2280.08-DRAWING REVISION SCHEDULE

PROPOSED SHADOW DIAGRAM - 21 DEC AT 9AM

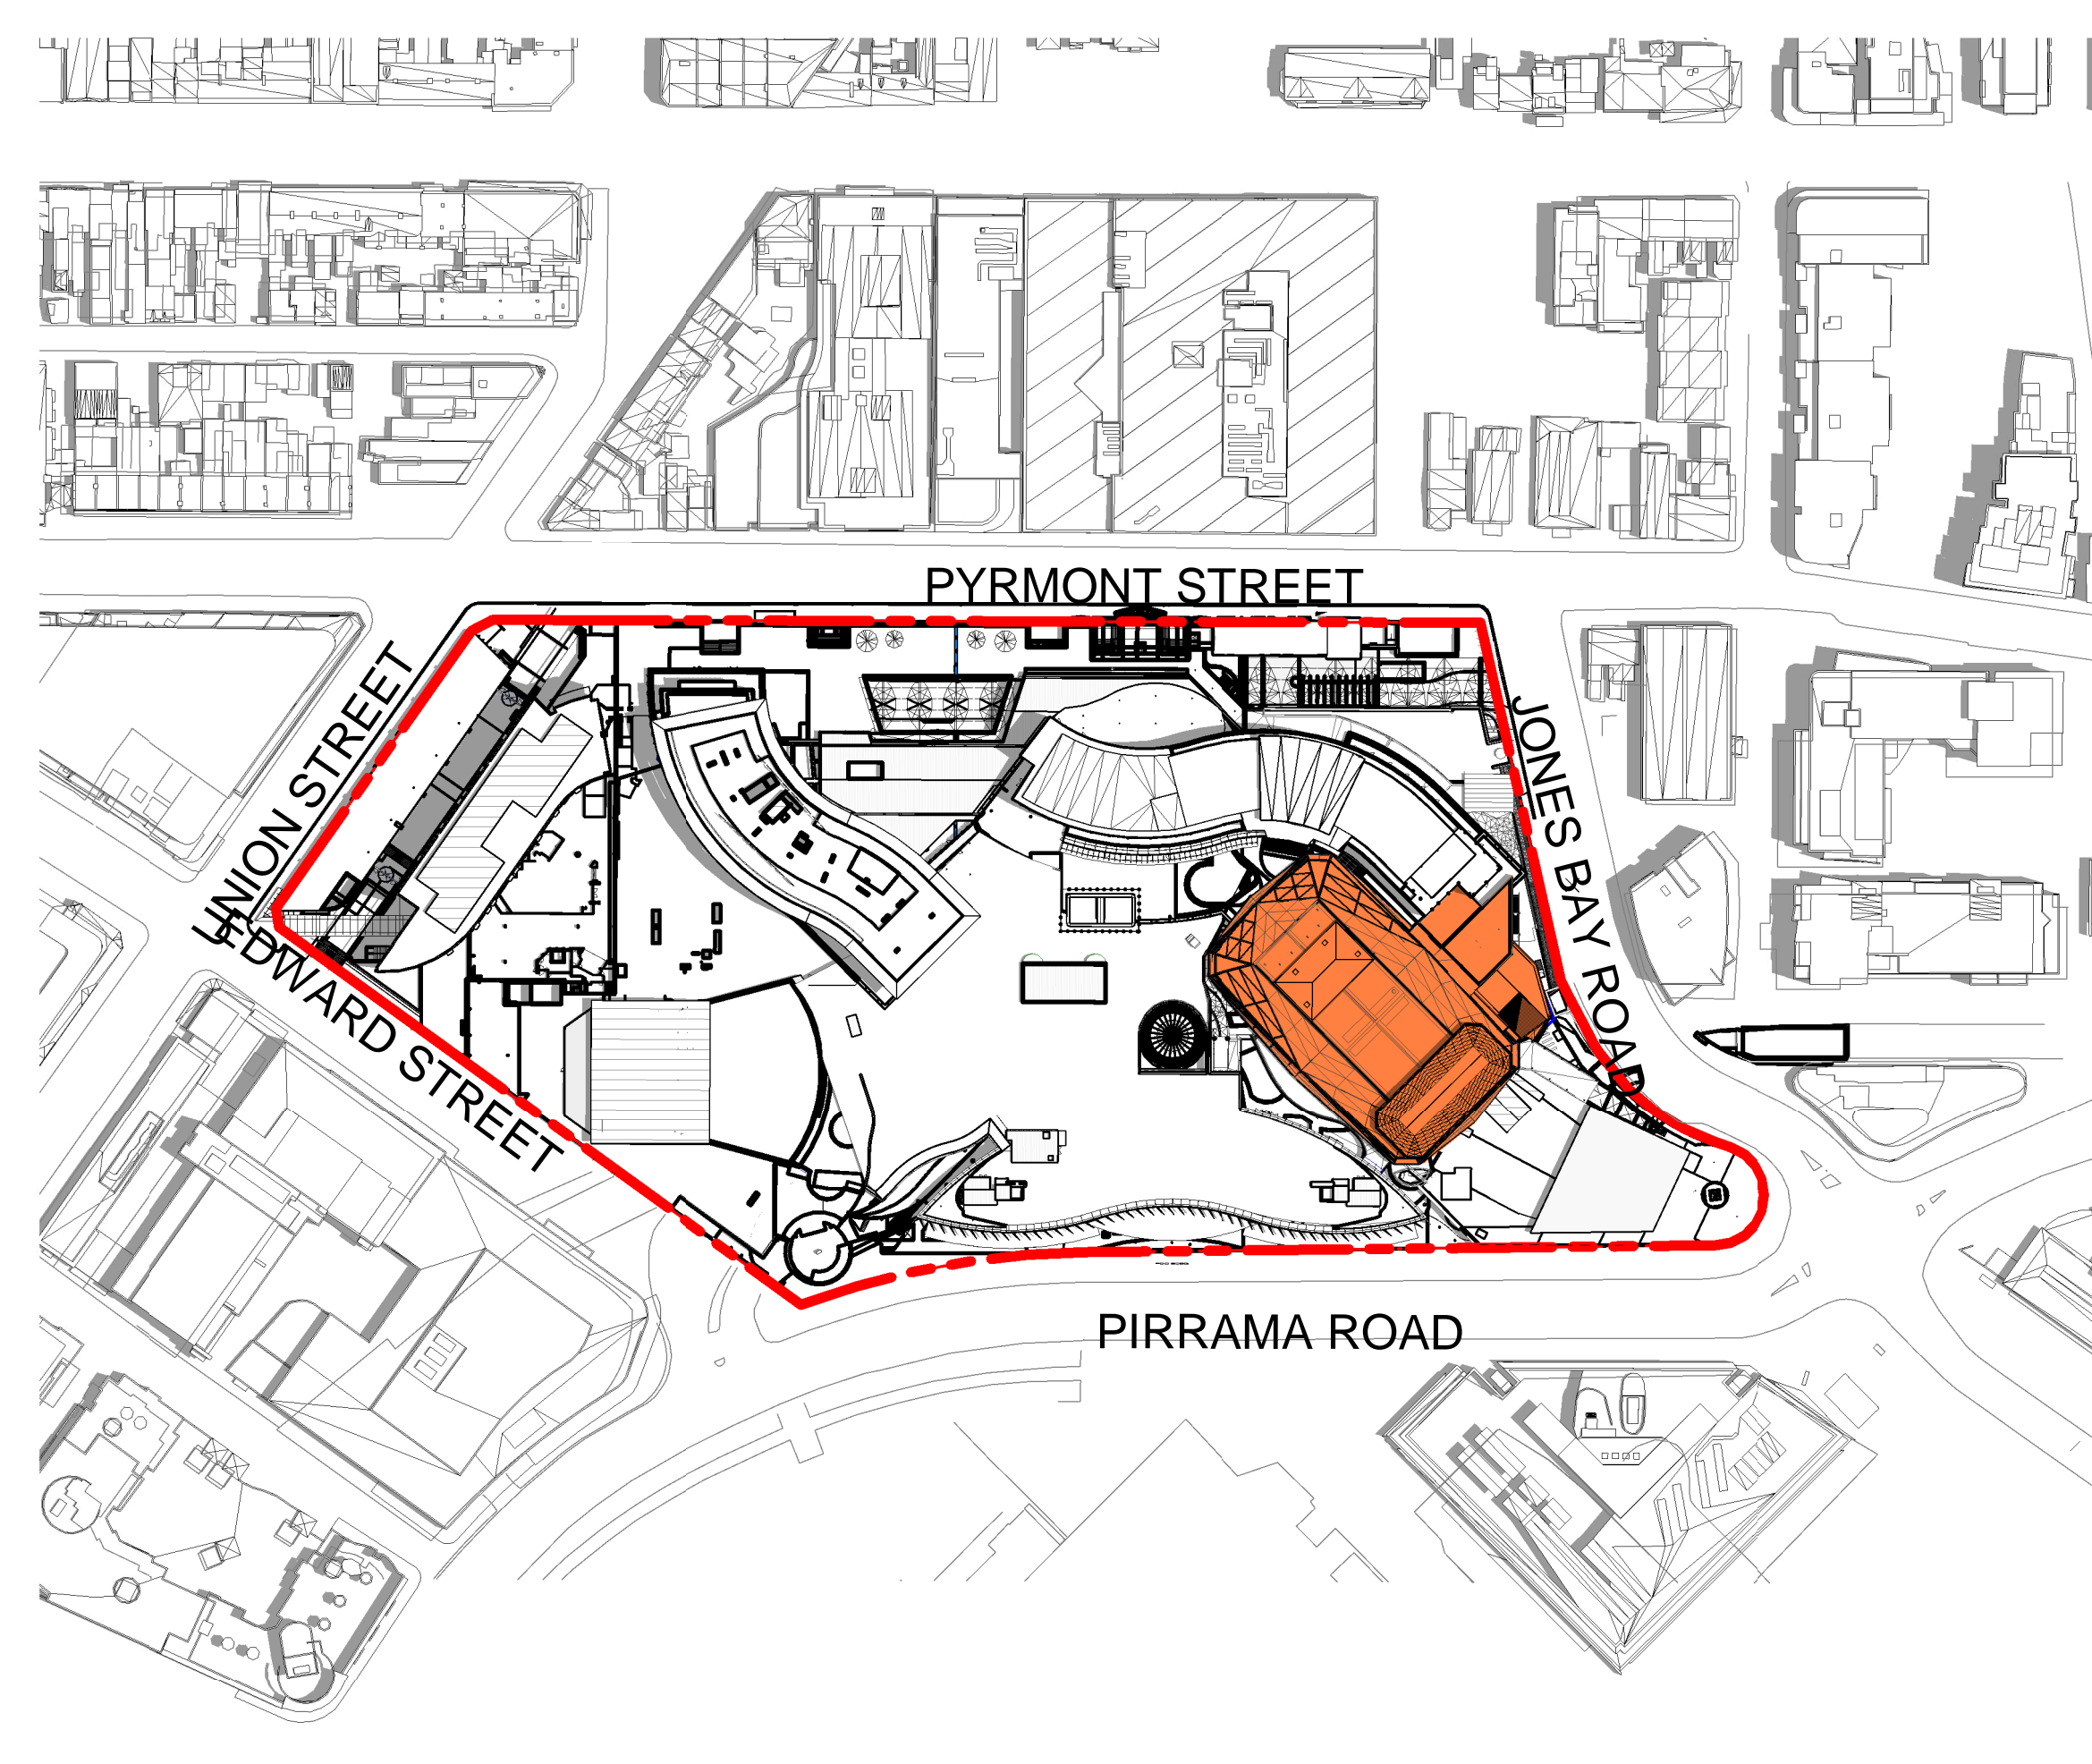
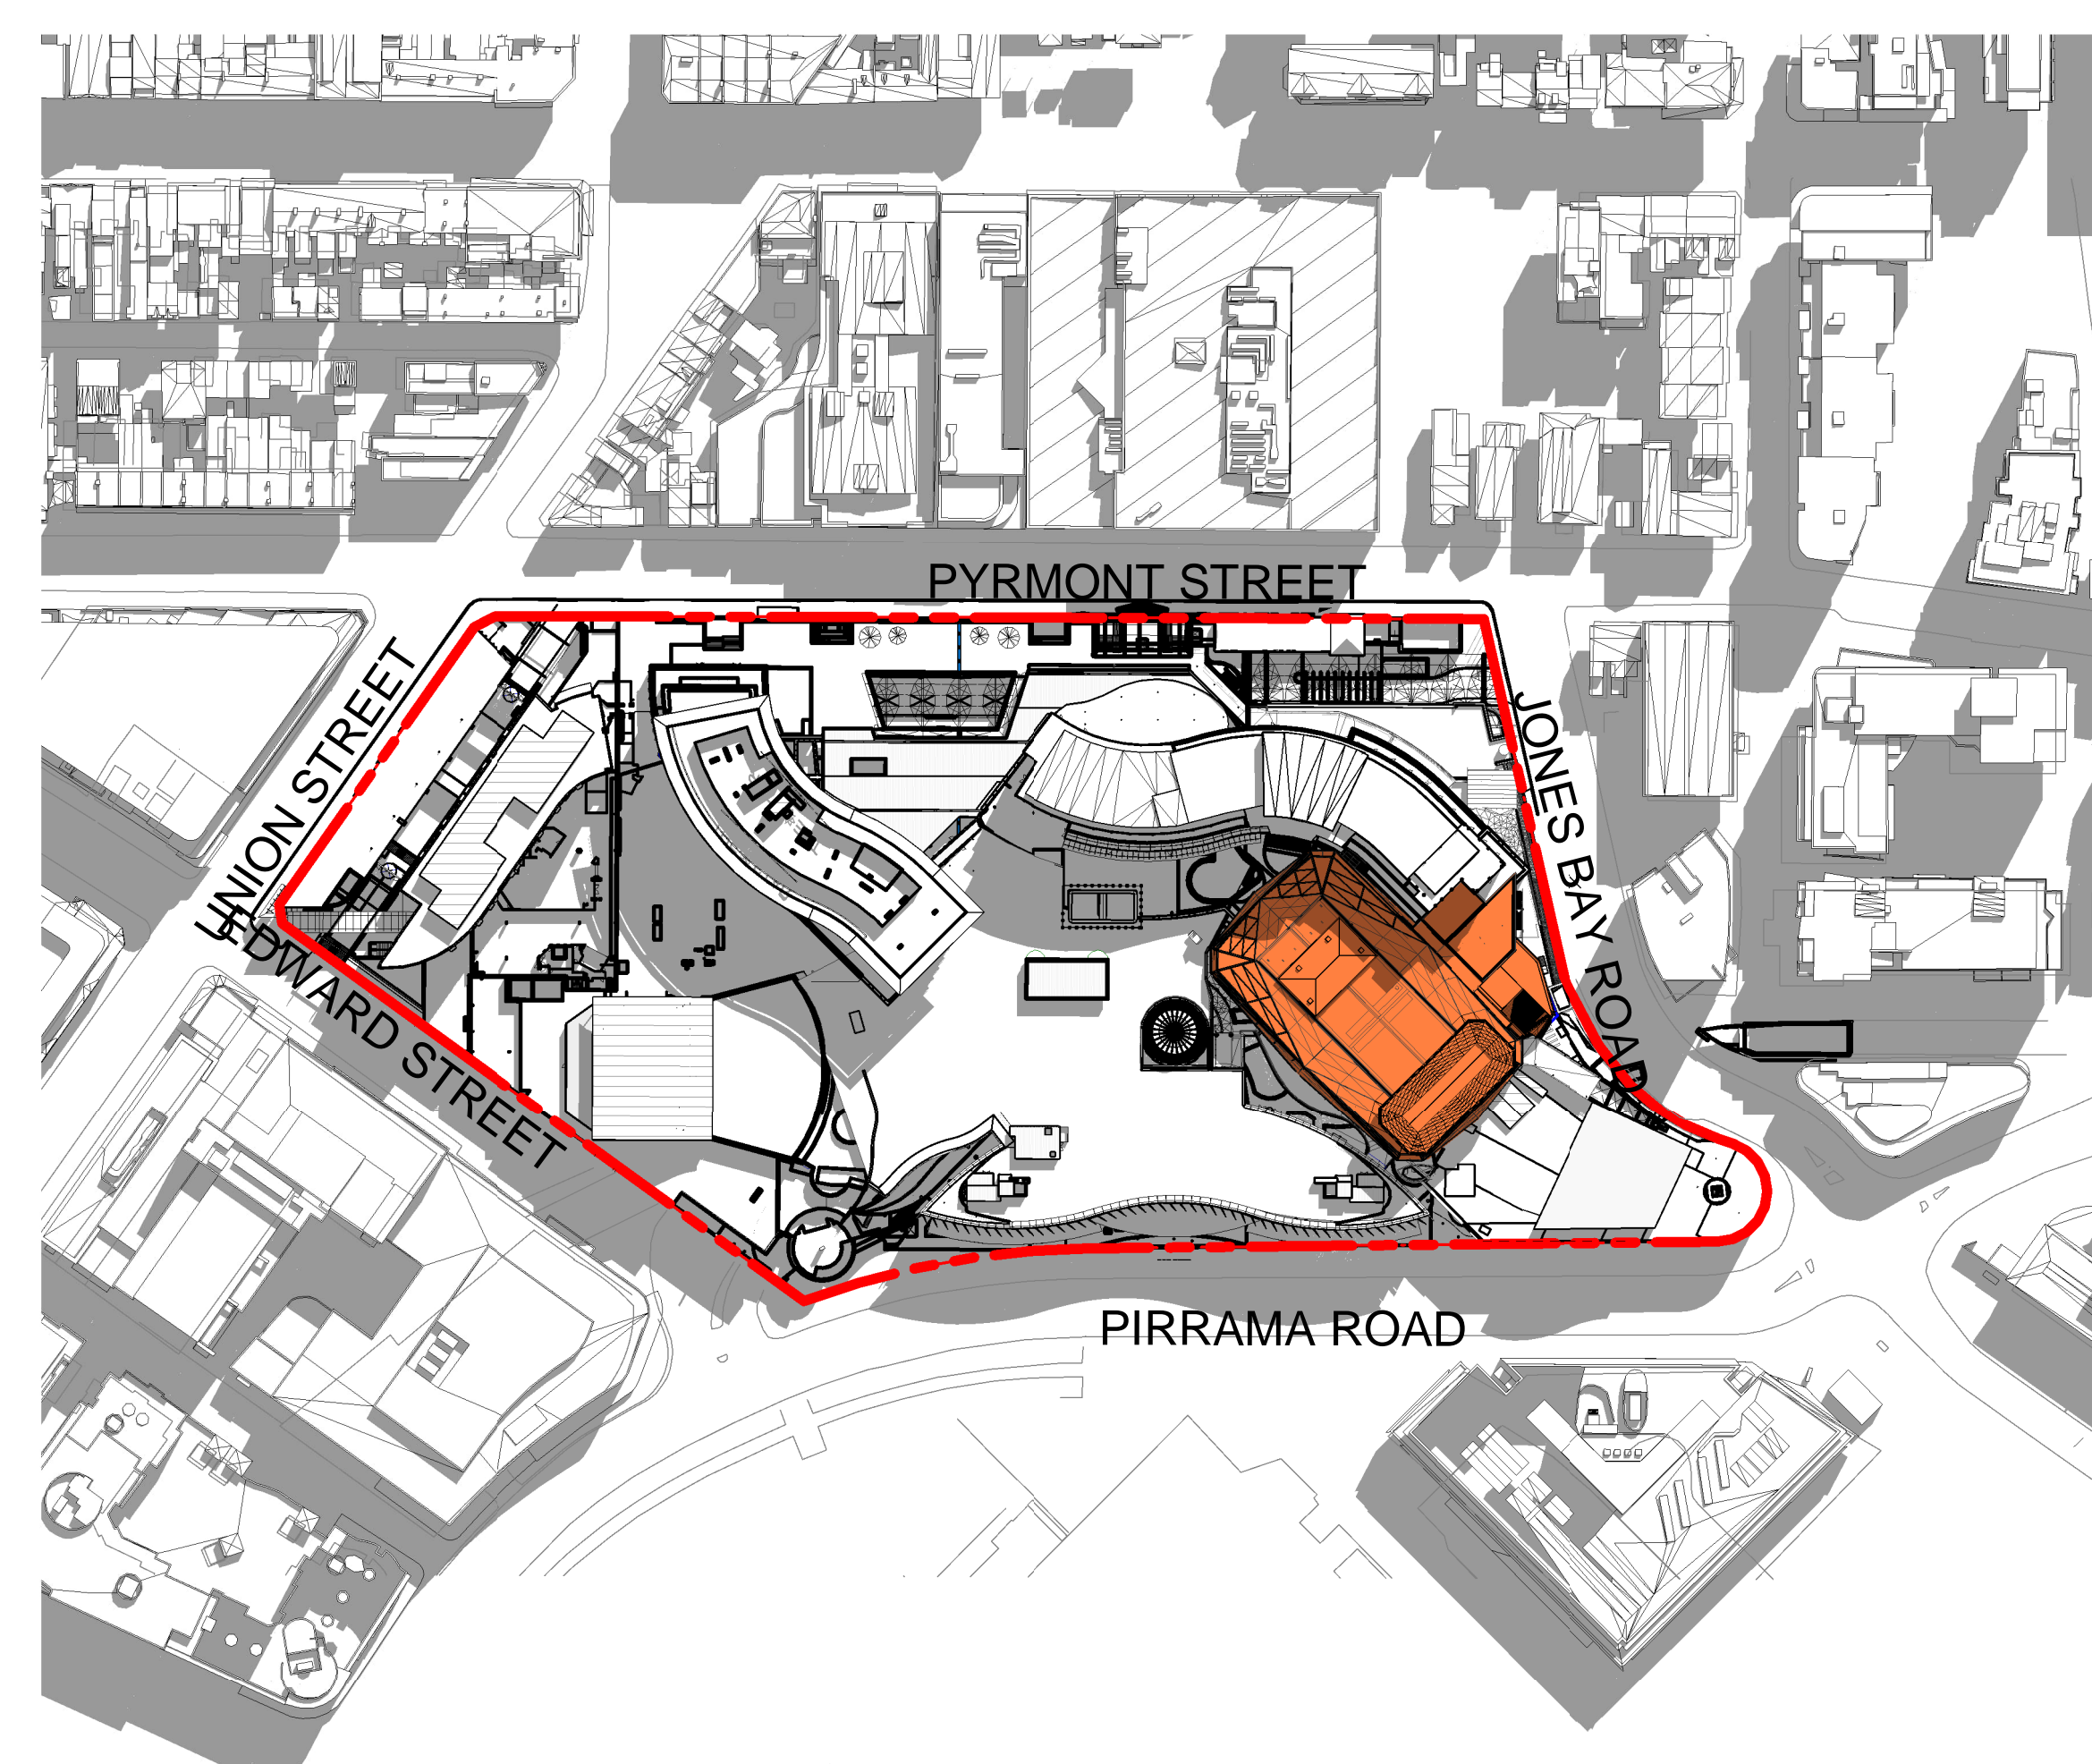
1. Footprint of fly tower reduced to suit comments from DPE and City of Sydney.
2. 4 level extension over existing dressing rooms reduced to 3 levels over existing dressing rooms. Aluminium clad screen extending from 4 level extension and on front of existing plant room omitted.
3. Double height plant room extension omitted from scope.
